CITY OF ALBUQUERQUE

March 8, 2022

**Re: US Eagle Credit Union- Menaul
7201 Menaul Blvd. NE
30-Day Temporary Certificate of Occupancy
Transportation Development Final Inspection
Engineer's Stamp dated 1-18-21 (H19-D090)
Certification dated 3-3-22**

TRAFFIC CIRCULATION LAYOUT
APPROVED
1/20/2021

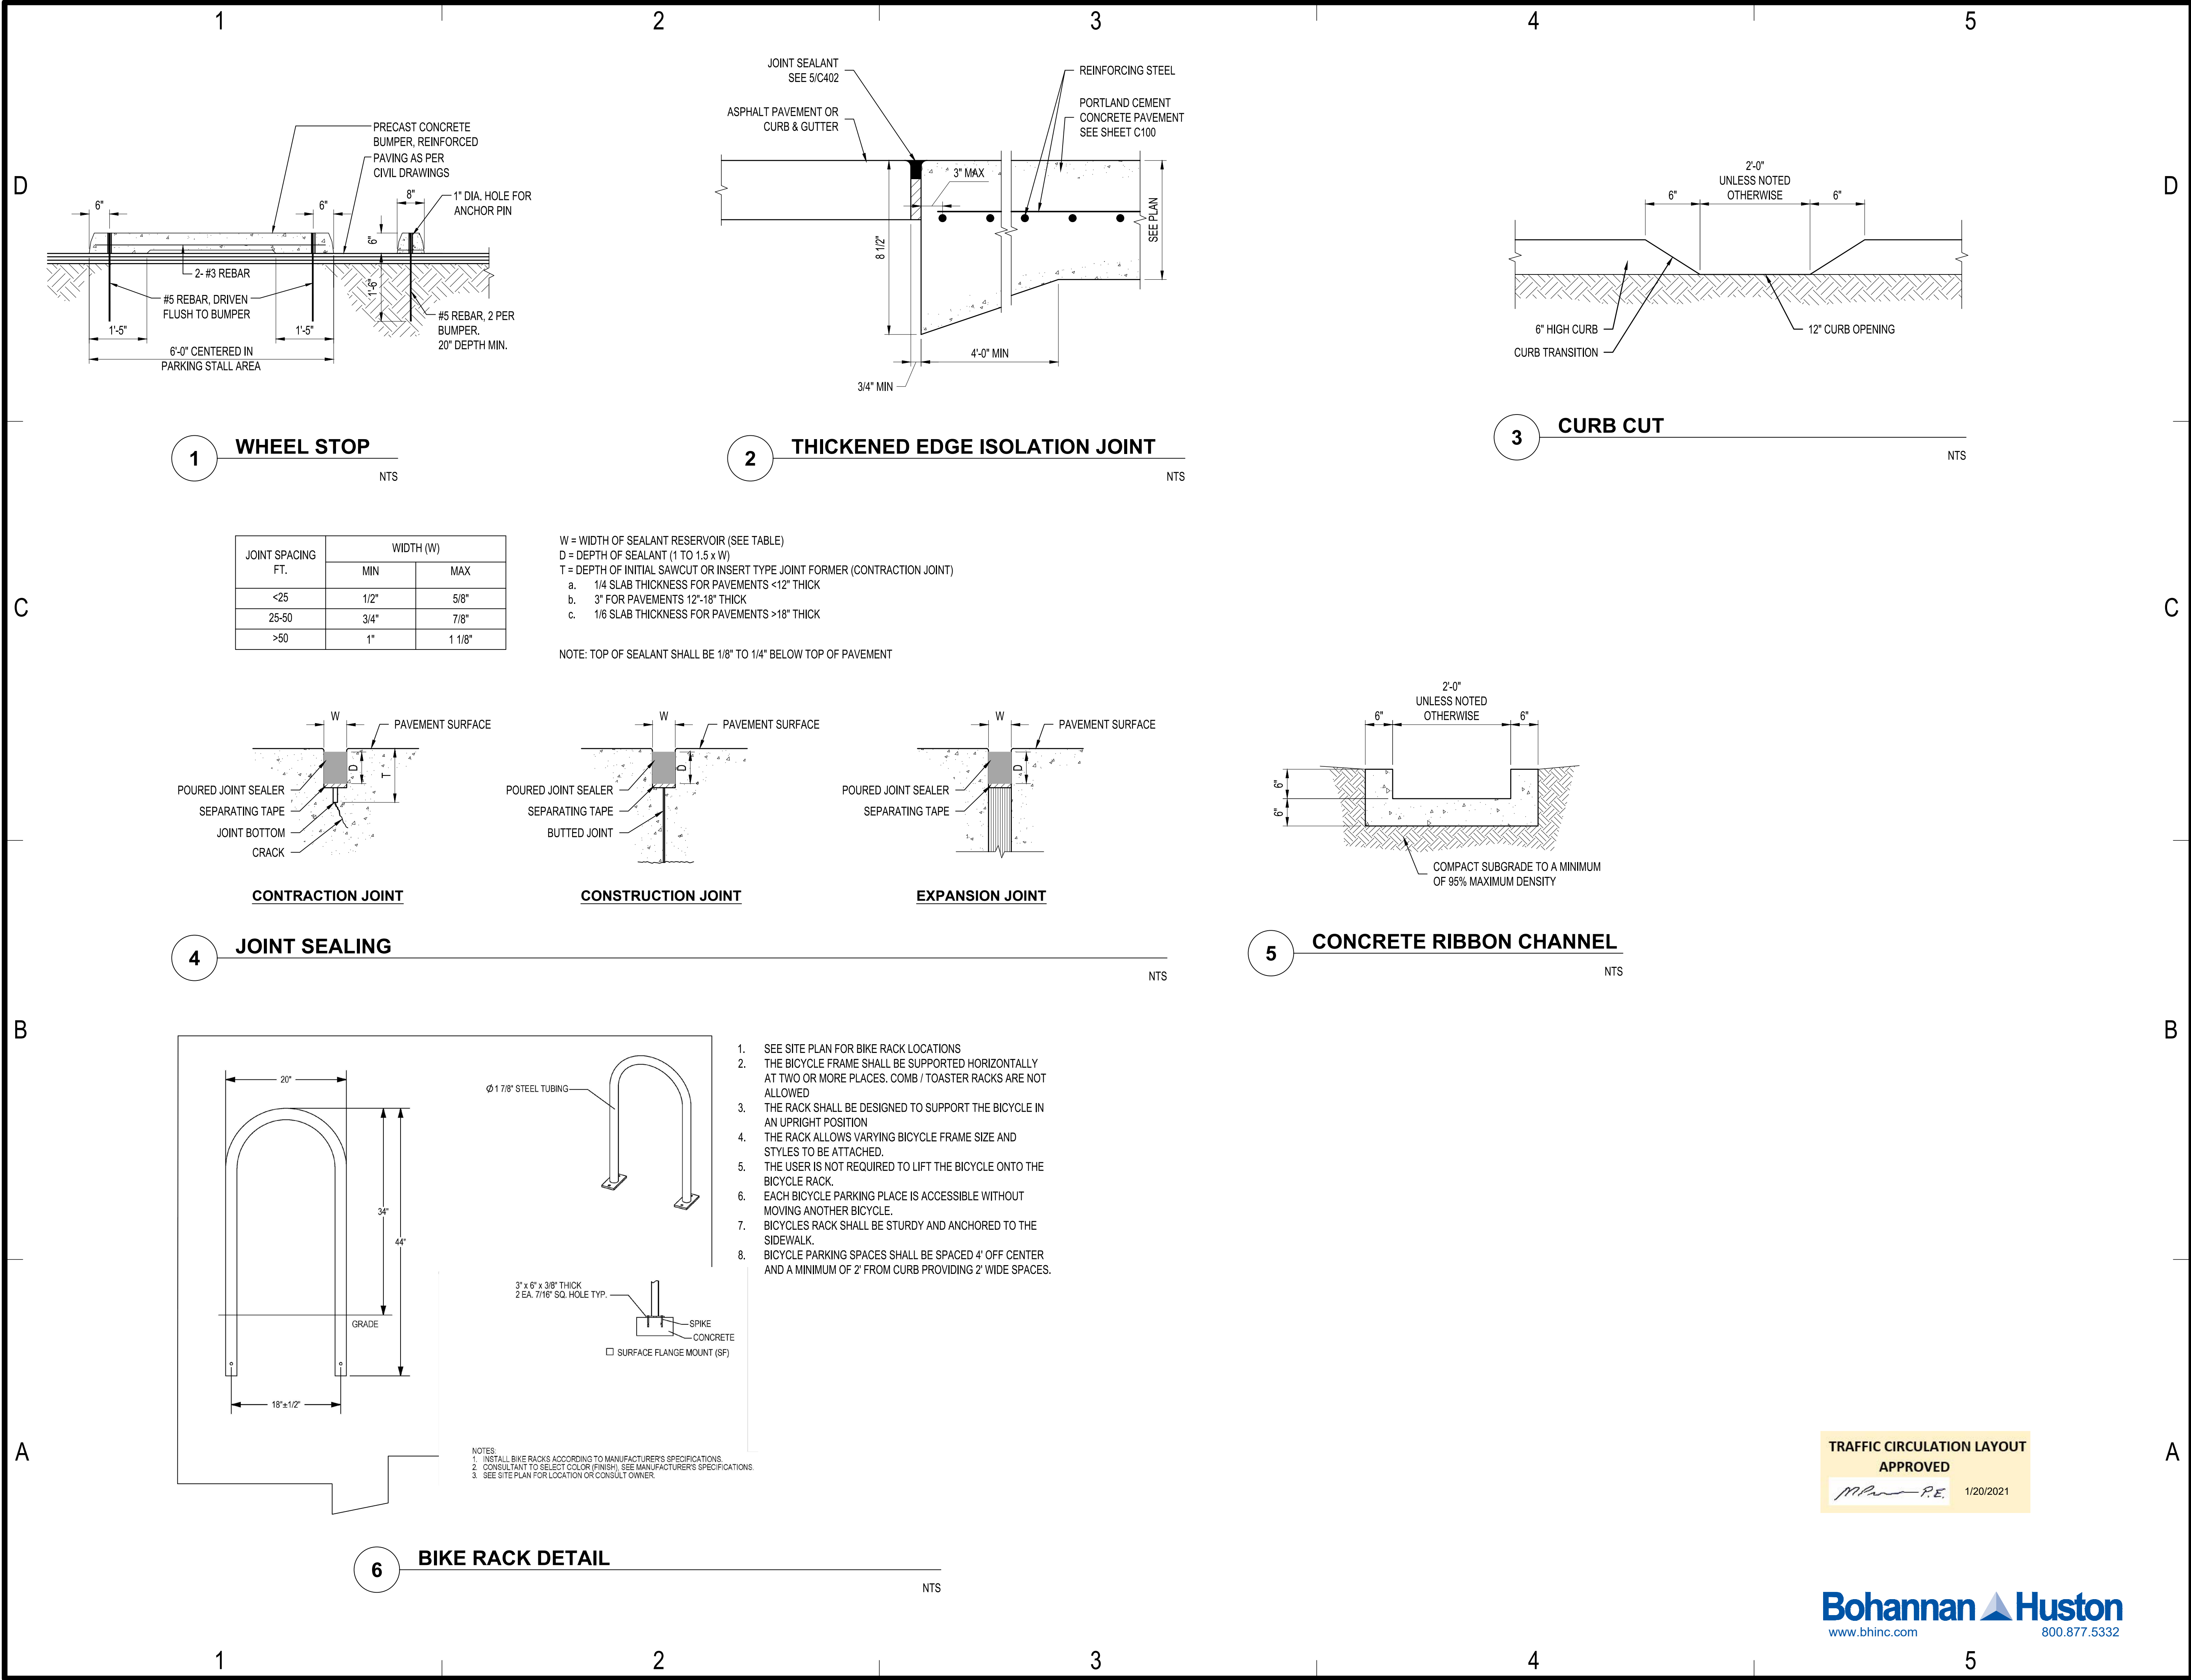
- DO NOT ENTER with the bar pavement marking need to be placed inside private property. It's on the city right of way.
